CITY OF ALBUQUERQUE

Re: Rite Con Office
519 Oliver Ross Dr. NW
Traffic Circulation Layout
Engineer's/Architect's Stamp **05-30-2019** (K09D042)

Based upon the information provided in your submittal received 06-18-19 the above referenced plan cannot be approved for Building Permit until the following comments are addressed:

UPC: 100905748834010309
 LEGAL LOT 8, BLOCK 3 CLIFFORD WEST BUSINESS PARK UNIT 1
 ZONING: NR-BP
 ZONE ATLAS PAGE: K9

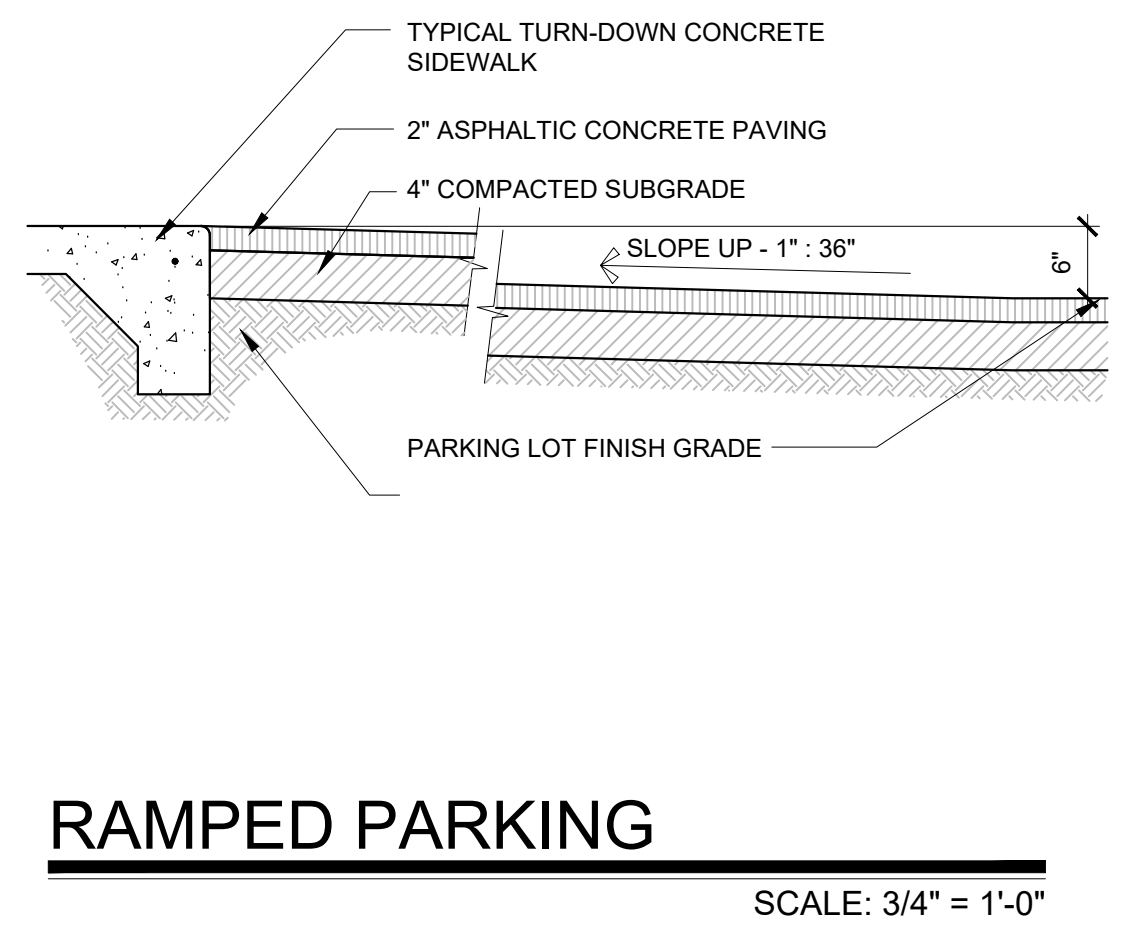
1. Per the IDO, a 6 ft. wide ADA accessible pedestrian pathway is required from the public sidewalk to the building entrances. Please clearly show this pathway and provide details.
2. Per DPM, a 6 ft. wide ADA accessible pedestrian pathway is required from the HC parking stall access aisles to the building entrances. Please clearly show this pathway and provide details.
3. provide a copy of refuse approval.
